October 31, 2024

Subject: Trails at Aspen Ridge Filing 1
Roadway Repair Recommendations
Colorado Springs, Colorado
Project No. 22.141

During a meeting on October 16, 2024 between representatives of El Paso County Department of Public Works, Colorado Land Acquisition (COLA), and CMT Technical Services - Colorado (CMT), proposed repairs to areas of utility trench settlement within the roadways of the subject development were discussed. CMT was requested to provide a summary of the proposed repairs. The purpose of this letter is to summarize CMT's recommendations.

A2.0

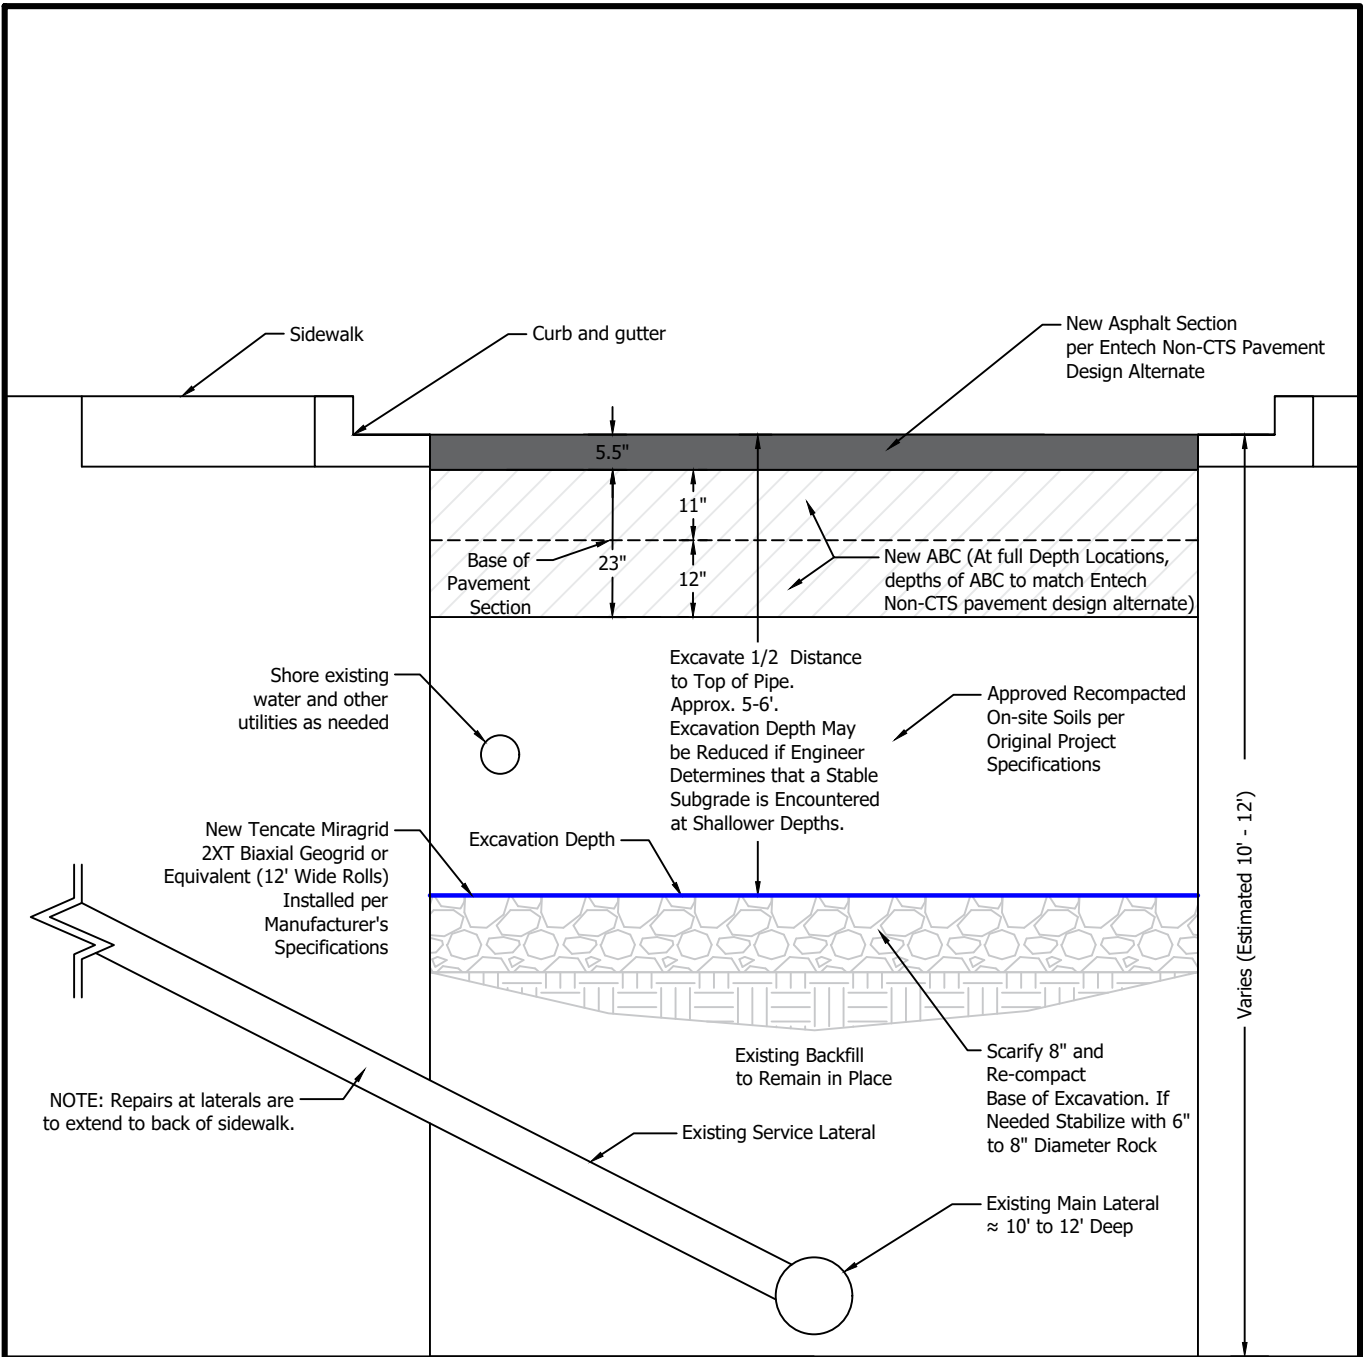
At all other locations, CMT recommends that the partial depth repairs be performed for the entire width of the street and extend to the back of the sidewalk at lateral locations. A plan view of the extent of the repair areas and a detail of the proposed repairs trench repairs are attached.

NOTE: Repairs at laterals are to extend to back of sidewalk.

A1.0		PROJECT NO:	22.141
		PROJECT NAME:	Trails at Aspen Ridge Settlement Evaluation
ASPHALT DISTRESS LOCATIONS Index		DRAWN BY:	MSR
		CHECKED BY:	--
CMT TECHNICAL S E R V I C E S		DWG DATE:	09.04.24
		REV. DATE:	--

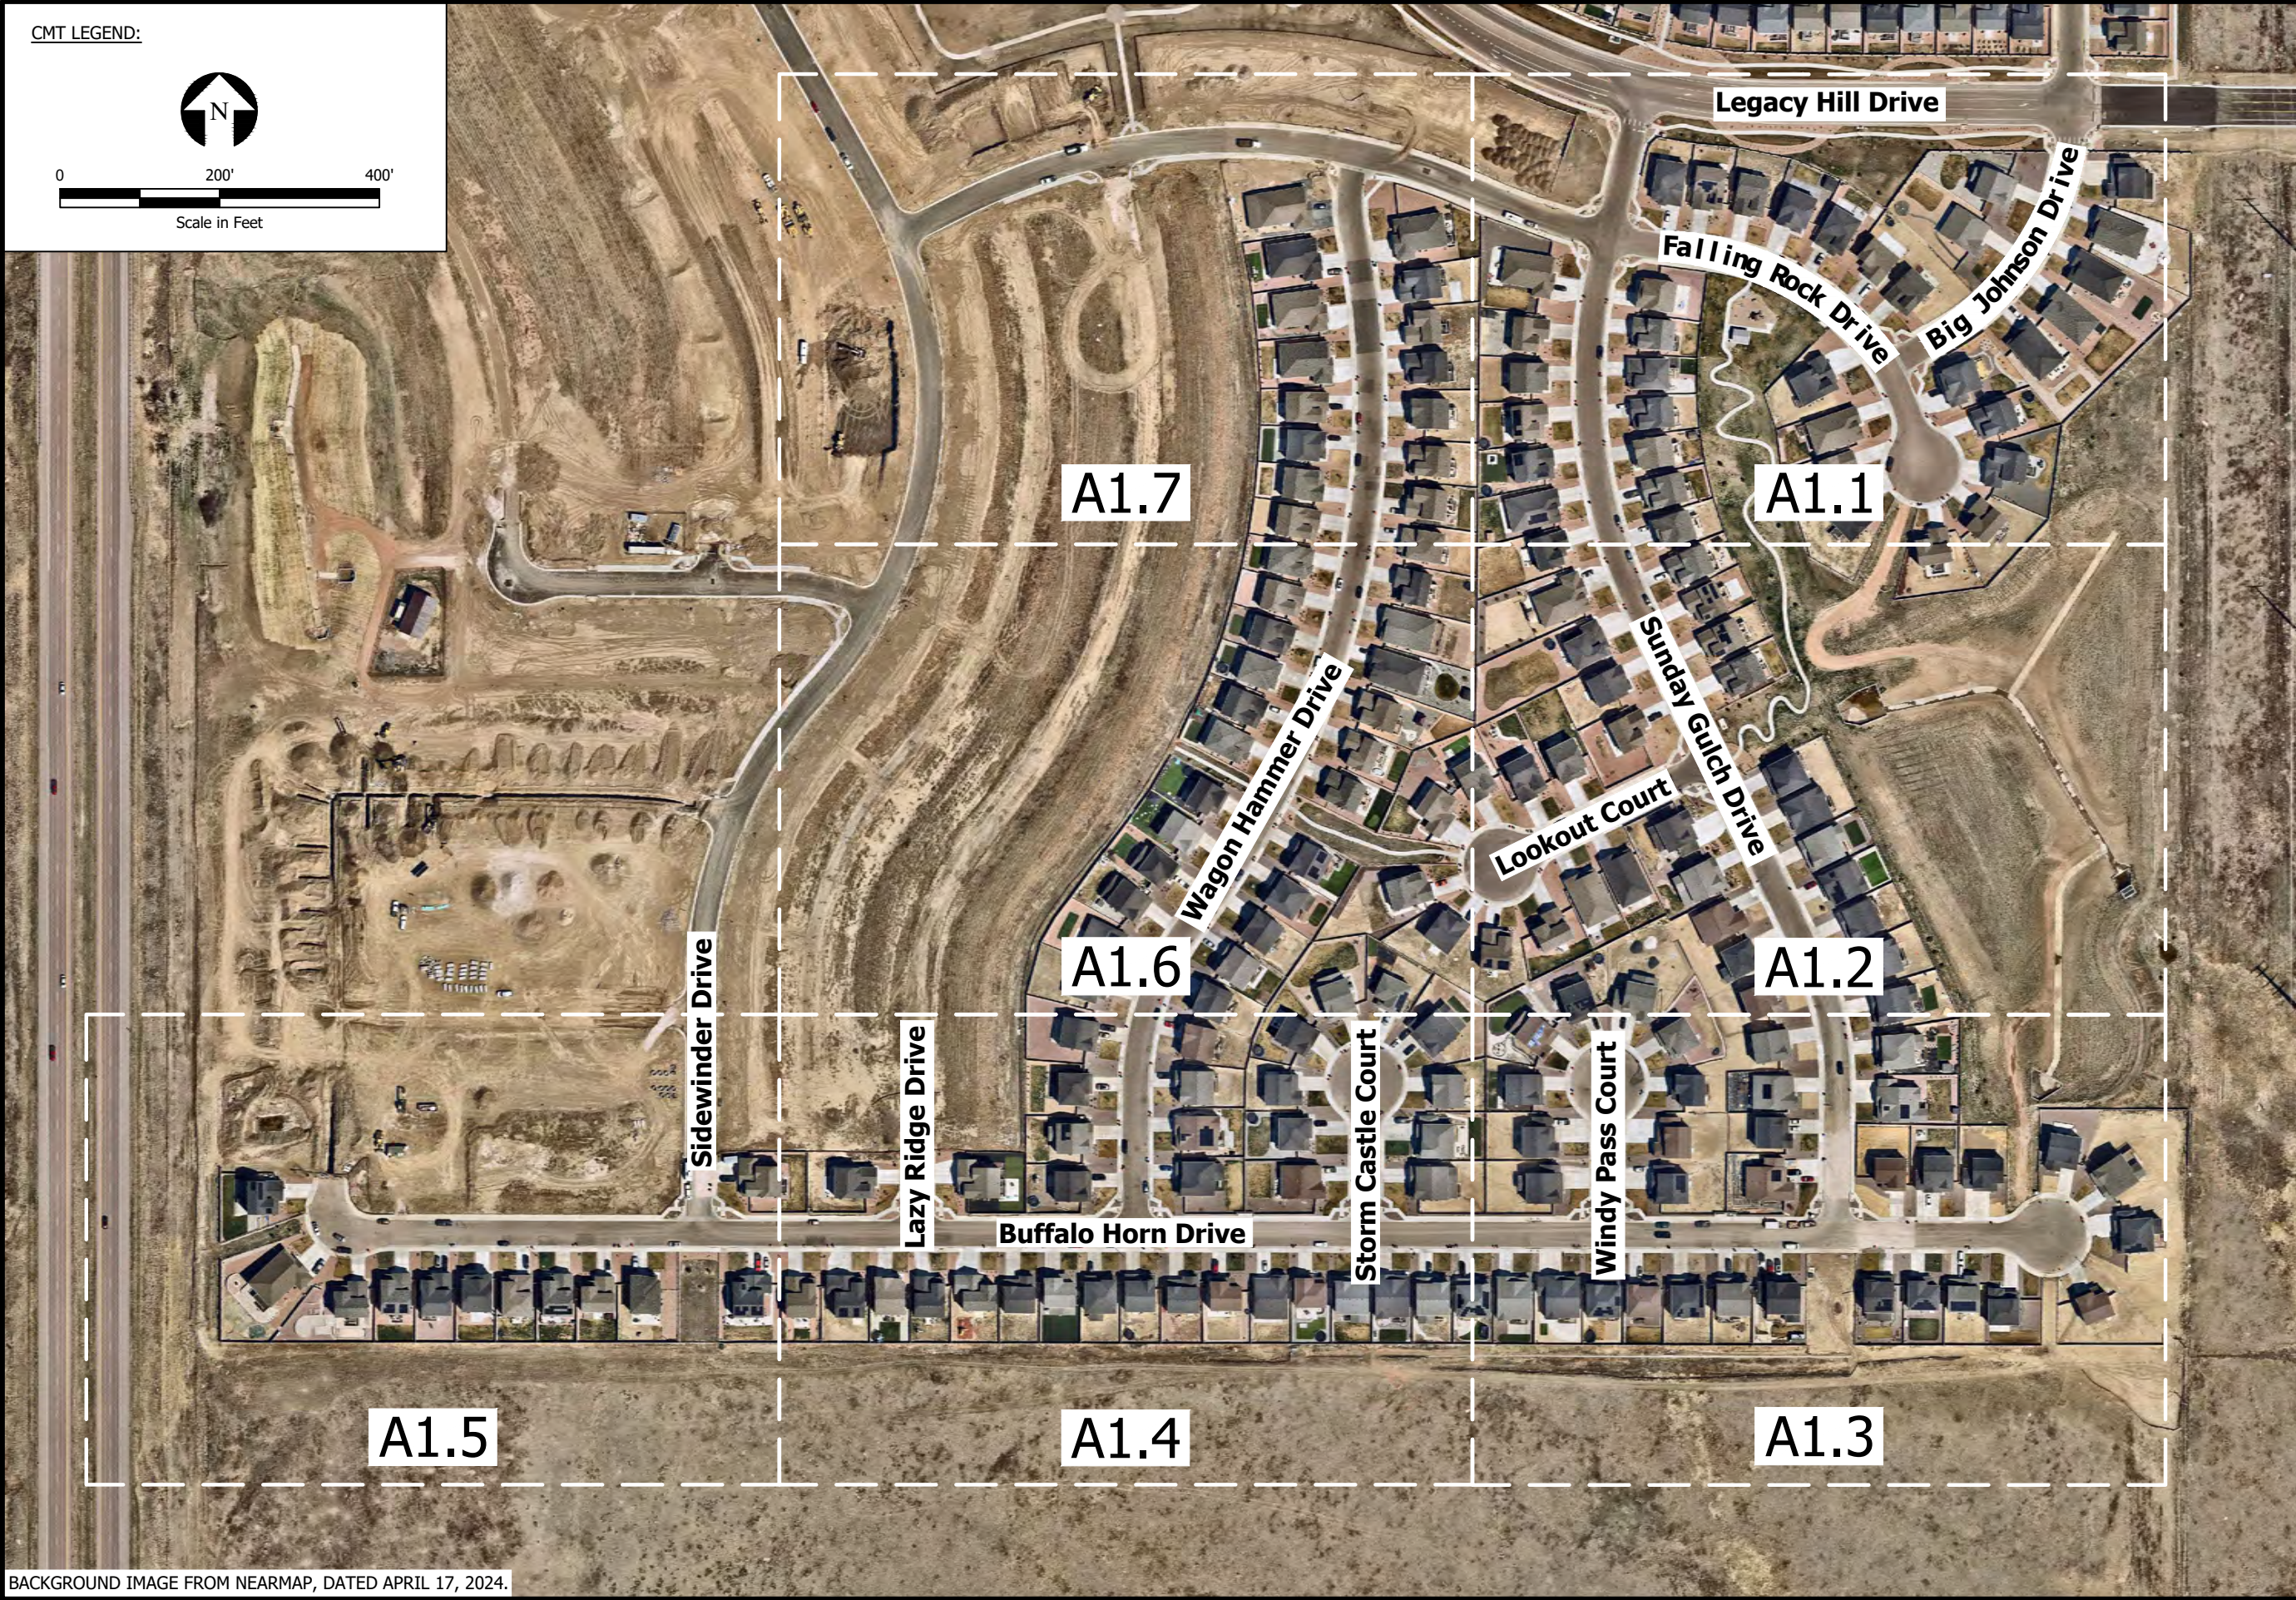
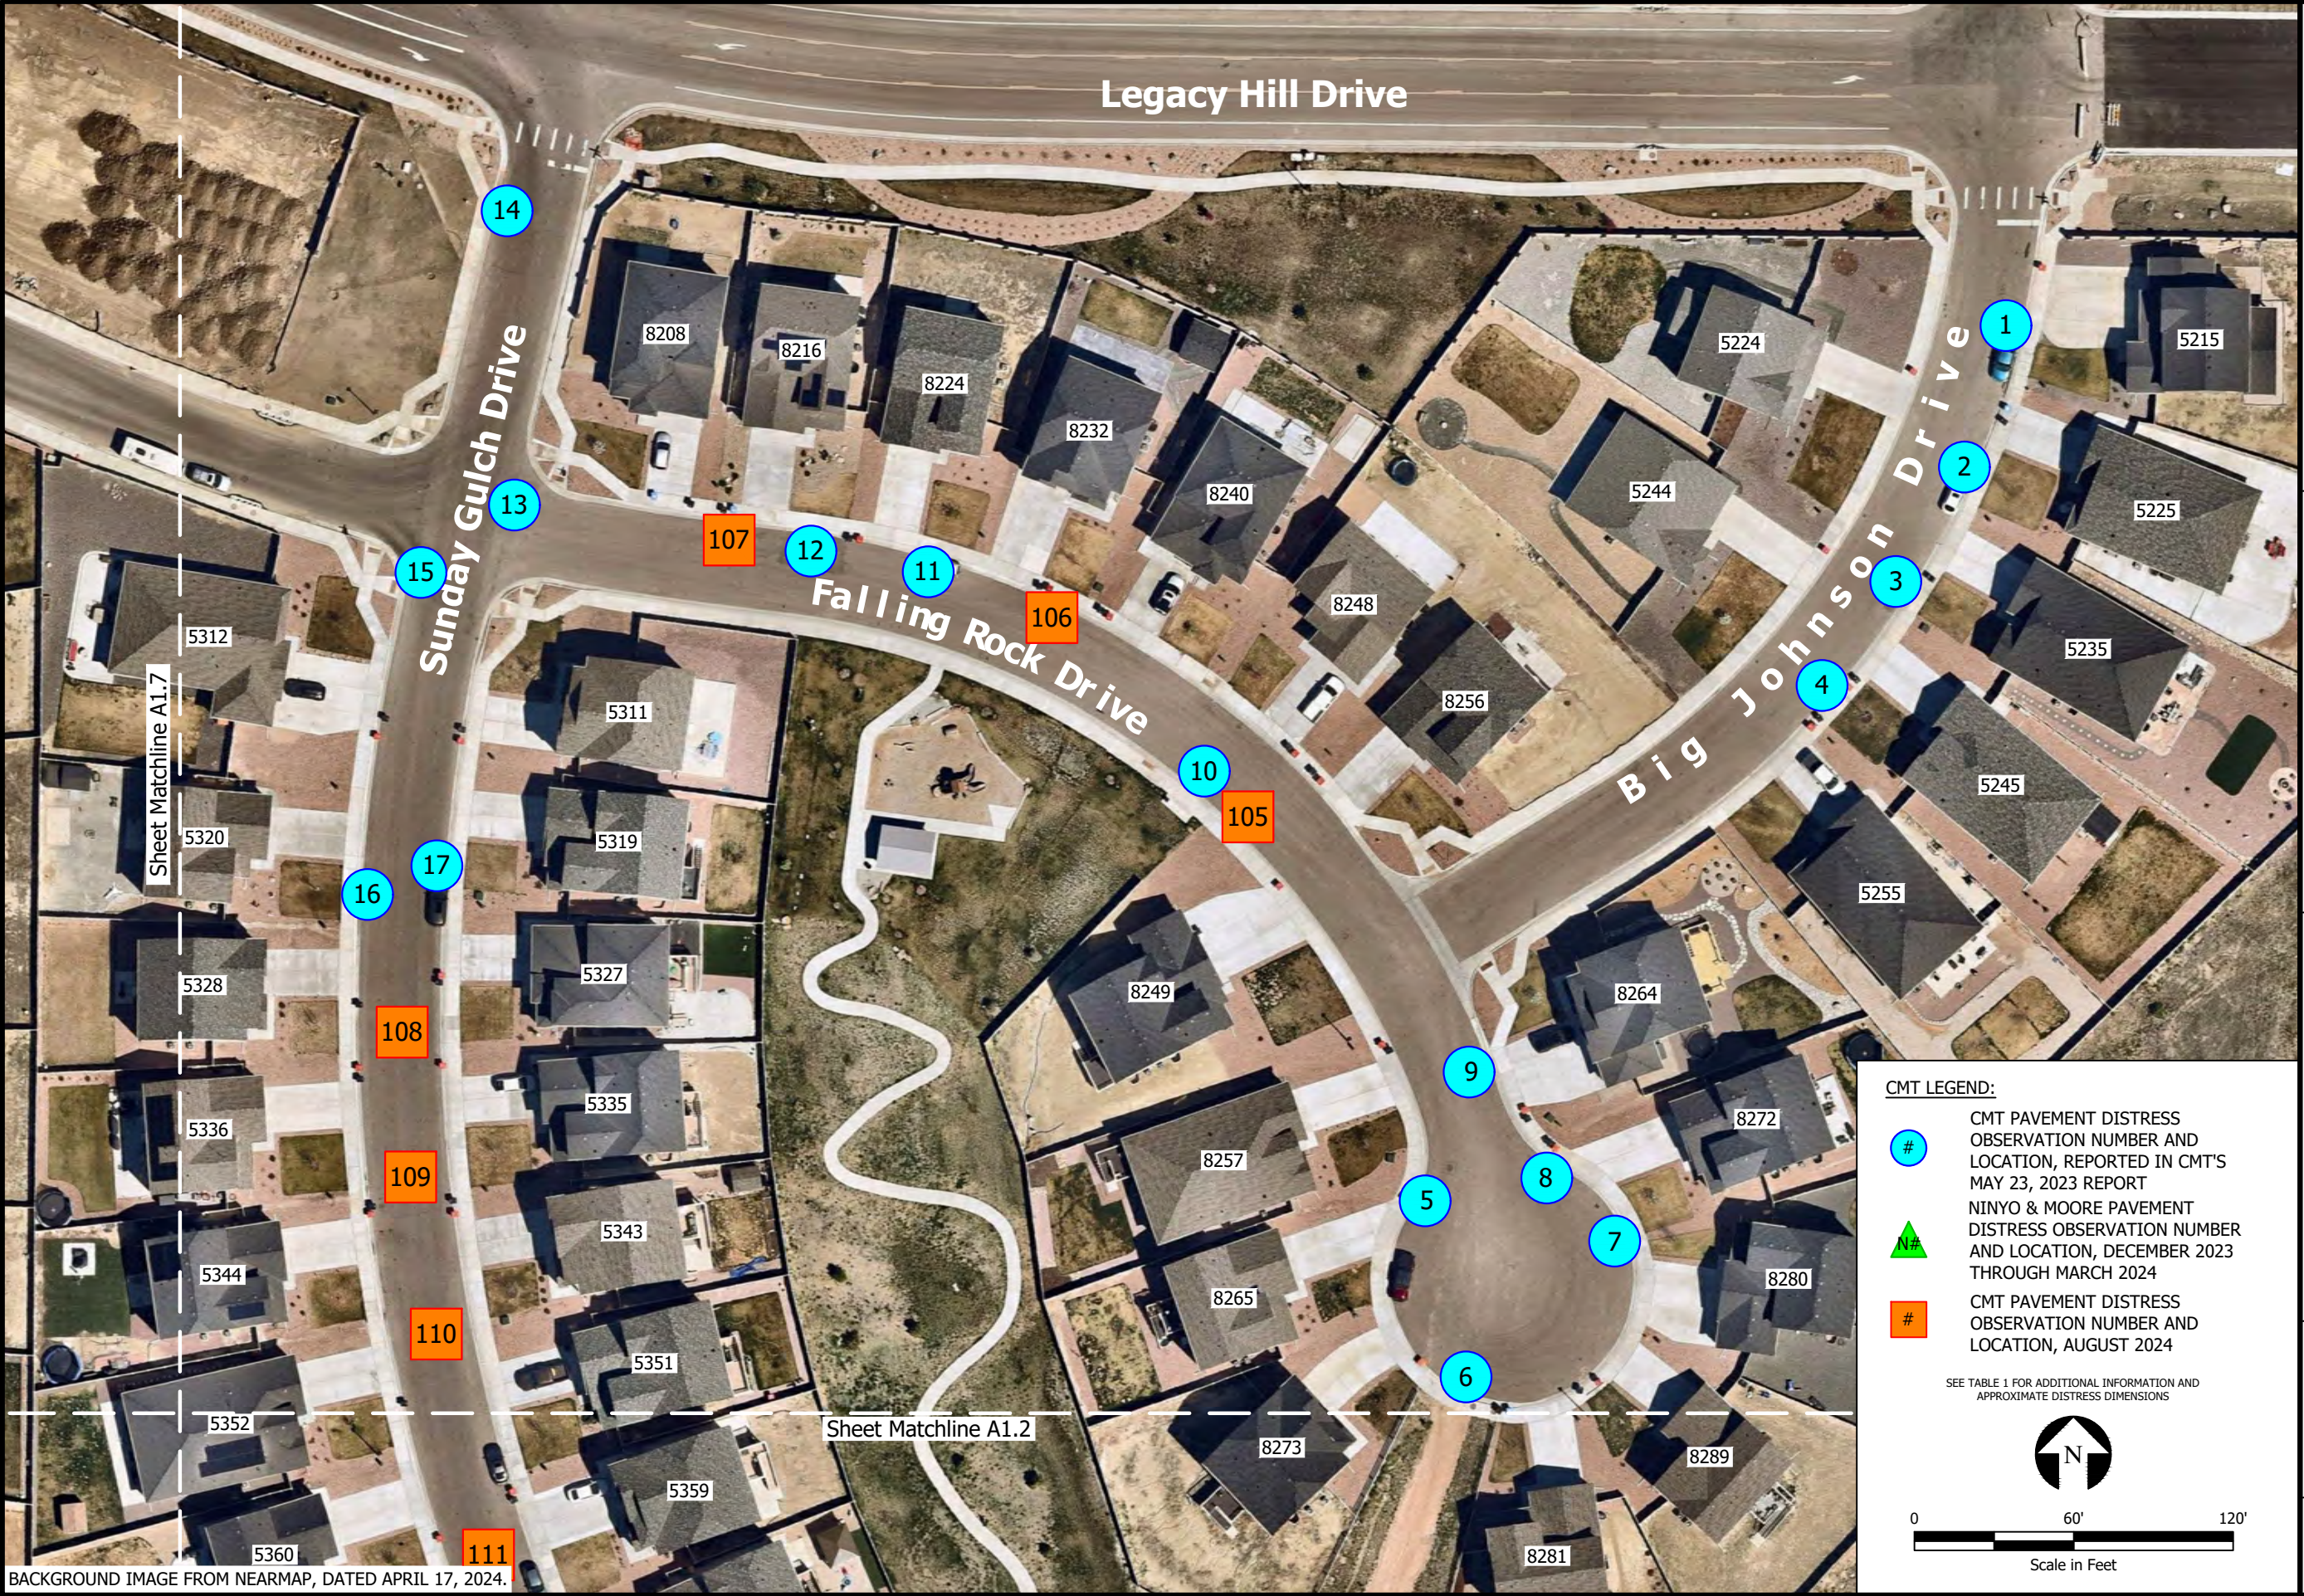
CMT performed observations in November 2022 and August 2024 to observe and document existing distress. CMT's observations are summarized in Tables 1 and 2 and Figures A1.0 through A1.7, appended.

CMT observed that the number of distress locations increased, the severity of previously existing distresses increased, and distress within the mainline trenches had developed during the time period between CMT's November 2022 and August 2024 observations. CMT initially recommended performing isolated excavations where settlement had occurred within the service lateral trenches. The existing extent of distress does not allow for isolated repairs at laterals for a majority of the roadways in Filing 1. There are isolated sections of roads where the distress is still limited to the laterals and isolated repairs at laterals are still recommended. The locations where isolated excavations are recommended include:

- Big Johnson Drive.
- Falling Rock Drive.
- Eastern cul-de-sac of Buffalo Horn Drive.
- Storm Castle Court.
- Wagon Hammer Drive between addresses 5402 and 5426.
